In reply please quote: 19/08983
Your Ref: SSD - 10313

26 February 2020

FAIRFIELD CITY COUNCIL RESPONSE TO WESTERN SYDNEY GREEN GAS PROJECT – ENVIRONMENTAL IMPACT STATEMENT – SSD 10313

Figure 6 | Site access route. Blue line shows the originally proposed route in the EIS and the red line shows the revised route, as proposed in the Submissions Report (Source Submissions Report - Western Sydney Green Gas Project).

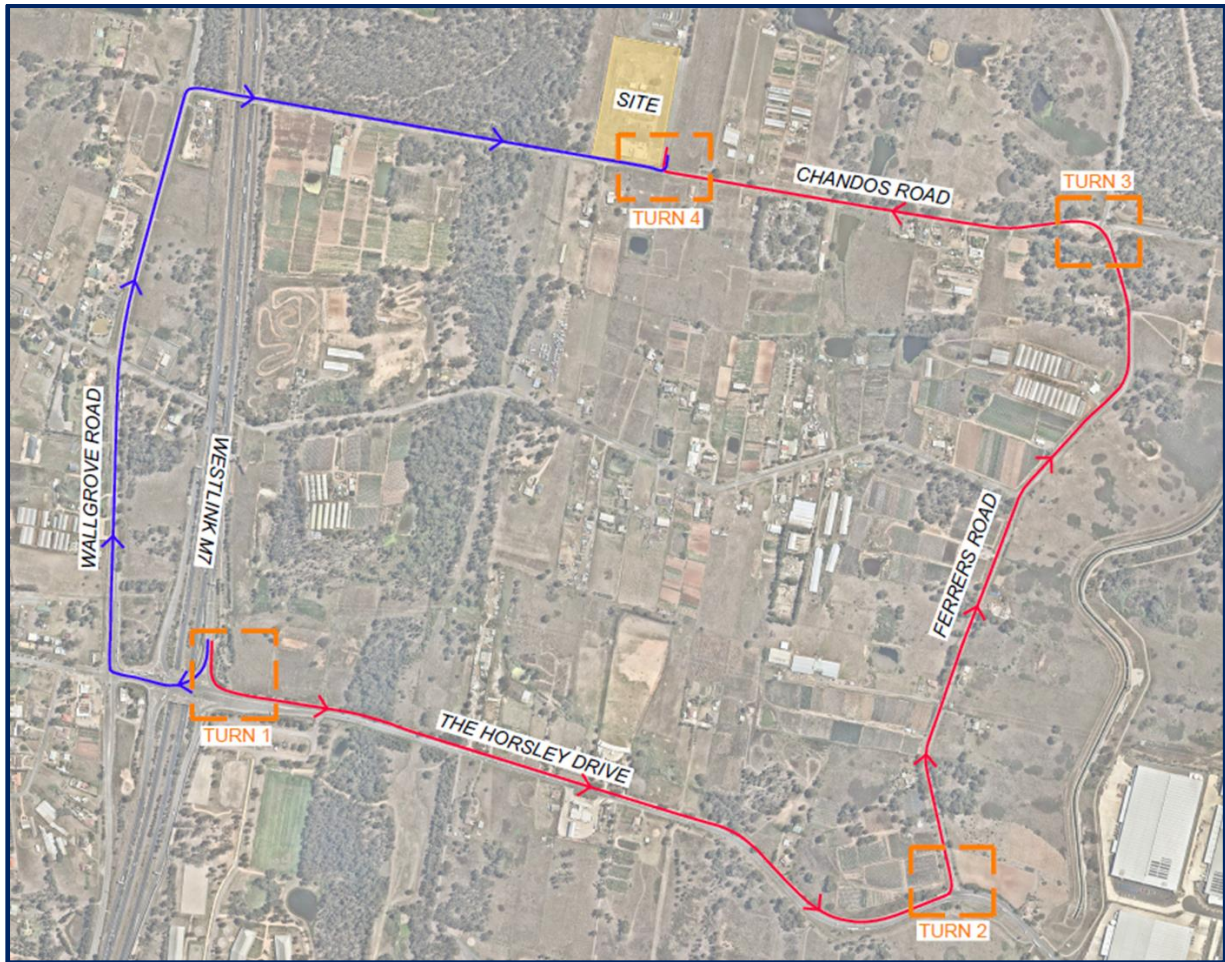
Traffic Movement – Considering the safety issues when turning into Chandos Road from Wallgrove Road, construction vehicles and buses, shall exit on to the Horsley Drive from the M7 Motorway, travel eastbound turning left towards Ferrers Road, travel northbound on Ferrer's Road turning left on to the Chandos Road and turn right into the site access road. The turning area required for vehicles to pass each other shall be sealed. Issues raised by Transport for NSW (formerly RMS) shall be satisfactorily addressed.
